2023/0454 – Planning Application

2023/0465 – Listed Building Consent Application

Address: Shore Hall Farm, Shore Hall Lane, Millhouse Green, Sheffield, S36 9LY

Description: Single storey timber framed and glazed extension to west elevation (Listed Building Consent)

title General Arrangement as Proposed  
number 22116D-02-P03  
scale 1:100  
size A1

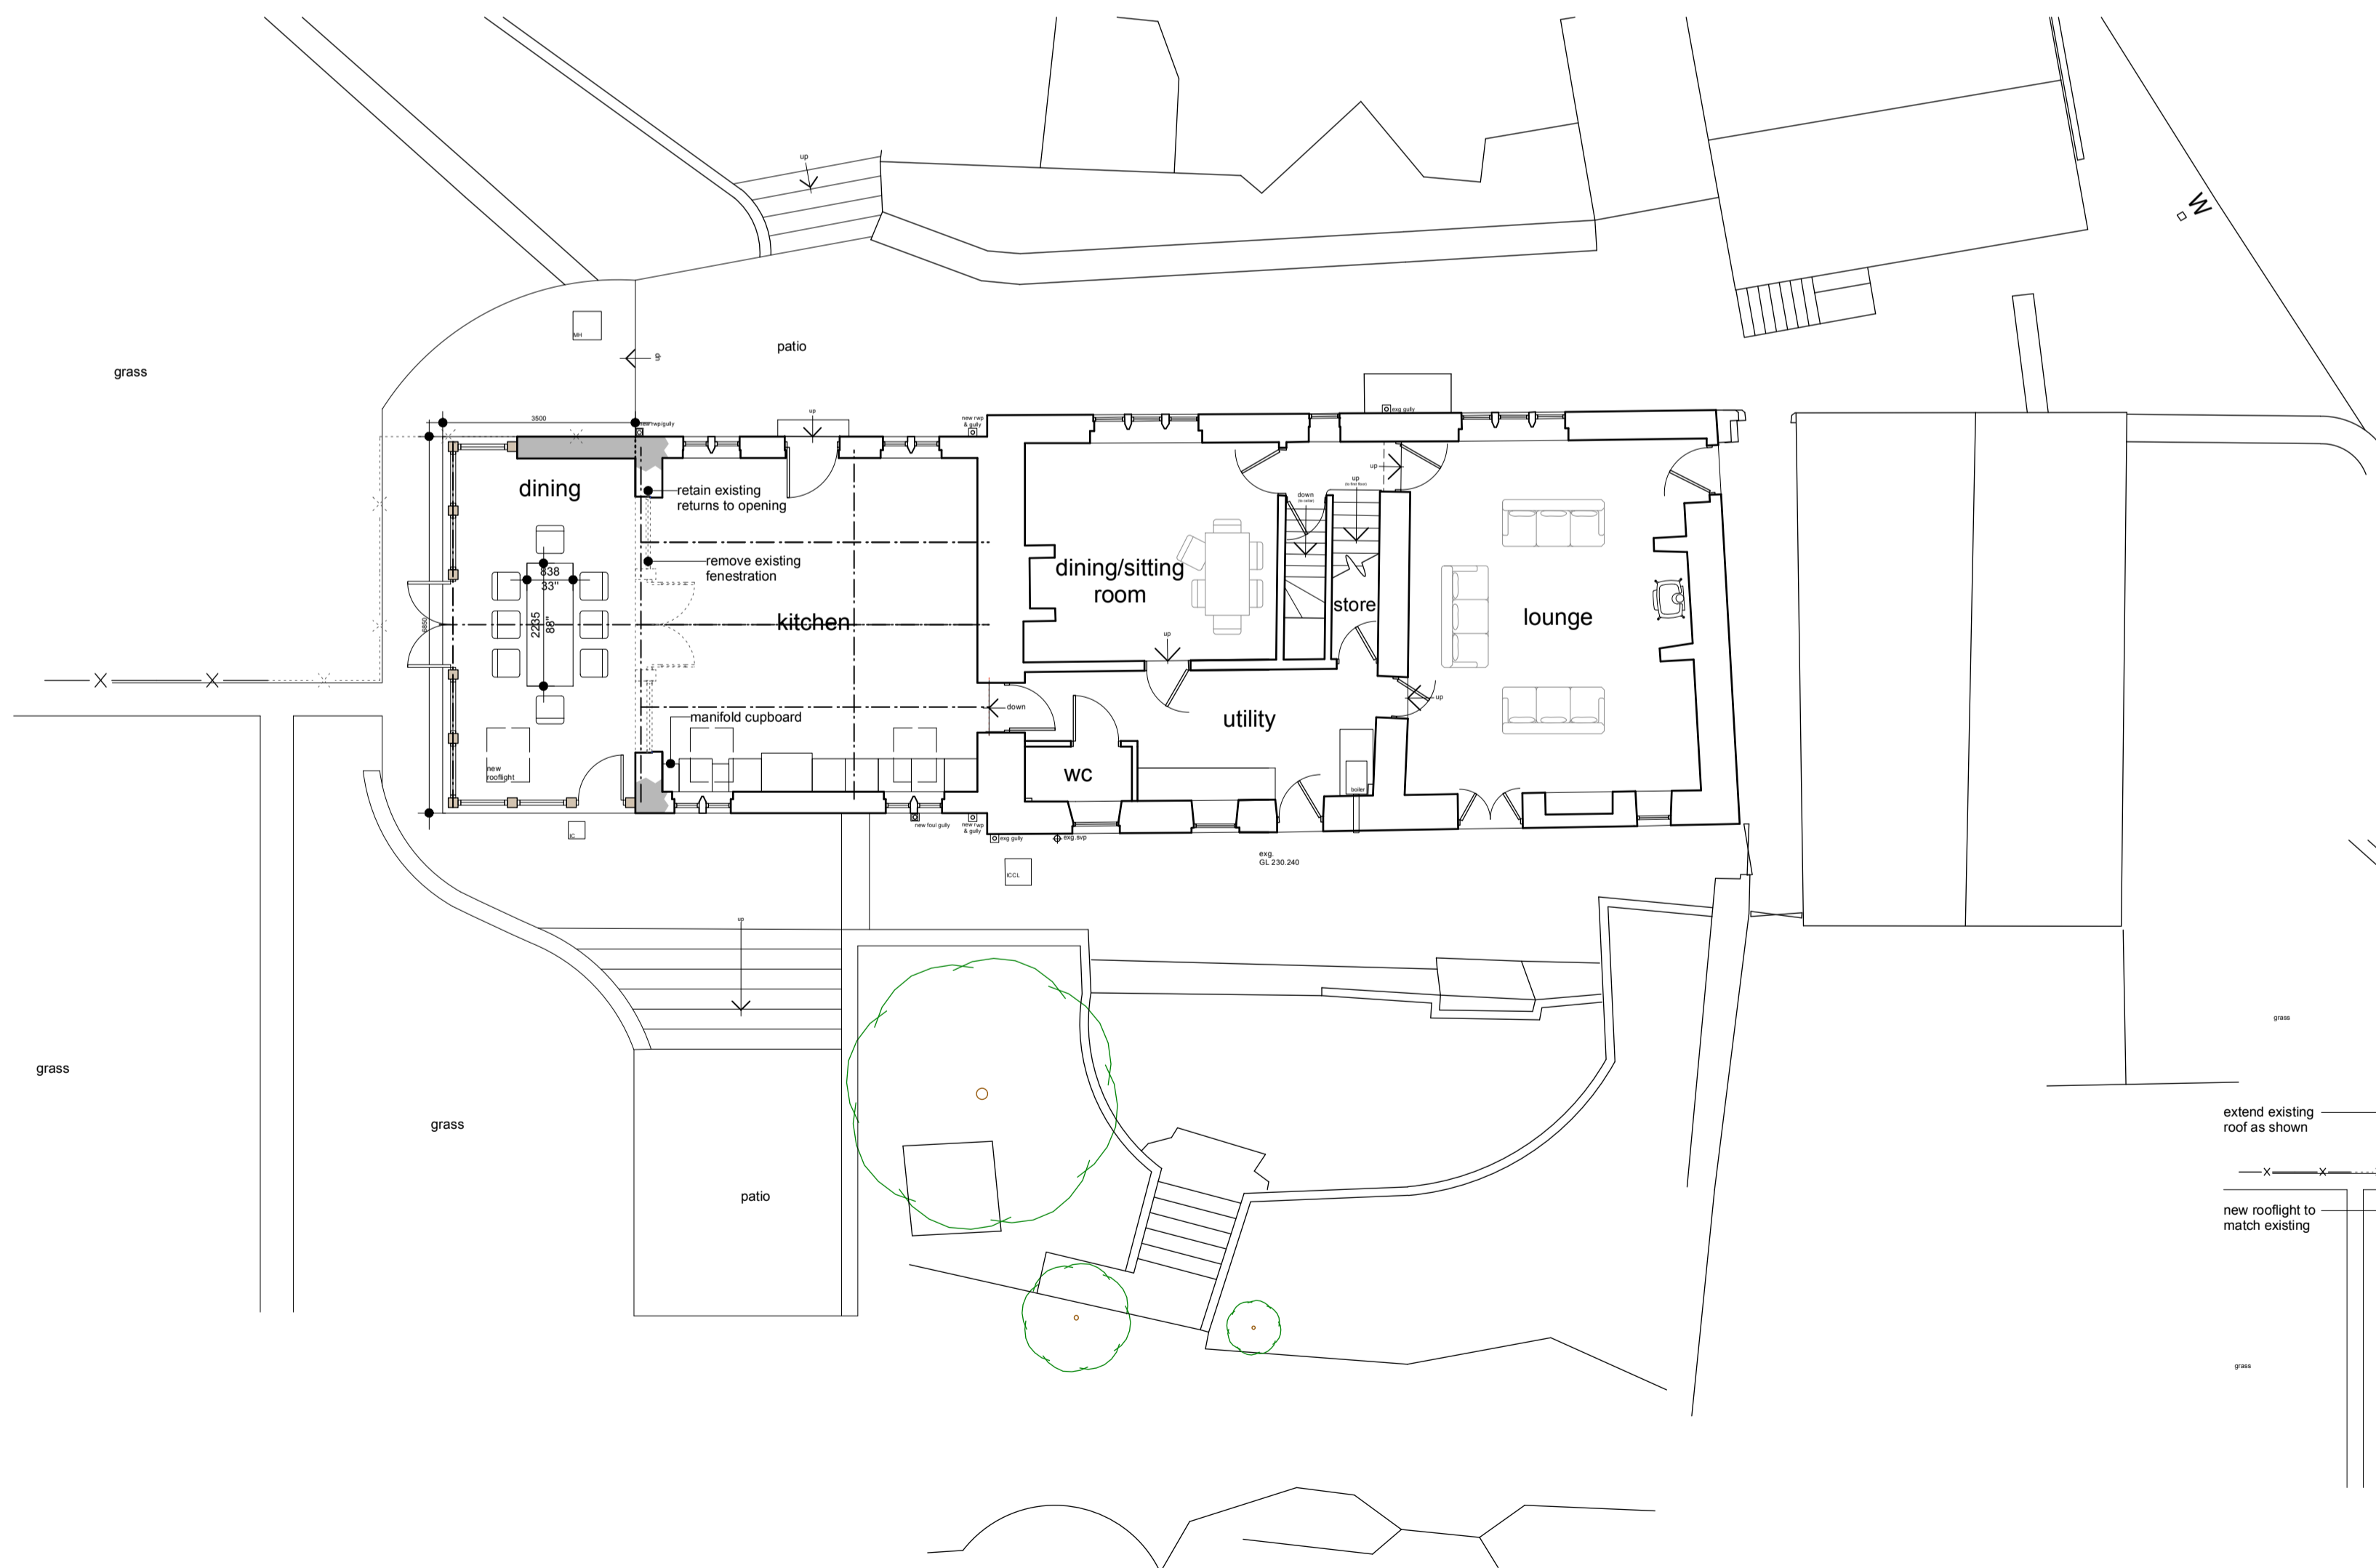
"In principle I see little harm as although the proposal will result in an extended footprint, the single storey element will still be deferential and not overbearing in the setting. I do however have a concern of the extent of glazing, primarily the glazing on the northern elevation which together with the fully glazed gable represents a significant shift in the overall solid to void ratio when viewed from the public realm. I make that point because the listed building is obviously of a vernacular style typical of the Pennine area with heavy sandstone walls, sandstone roofing flags and mullioned windows. Overall, glazing is quite restrained in amount and appearance. Consequently, there is a disconnect in the glazing of the new proposal vs that of the principal listed building. I have discussed this with Natalie Garside at ADP who has suggested a small redesign to include further masonry on the northern elevation up to the (currently proposed) second timber mullion. This would allow the corner to still remain glazed and continue the glazing around on onto the western facing gable. Assuming this is acceptable to the applicant, I would not object to this re-design and see it as a reasonable compromise that mitigates the new glazing and avoids it becoming over dominant."

After submitting amended plans, taking onboard the concerns mentioned in the above statement, the Conservation Officer was satisfied with the proposal.
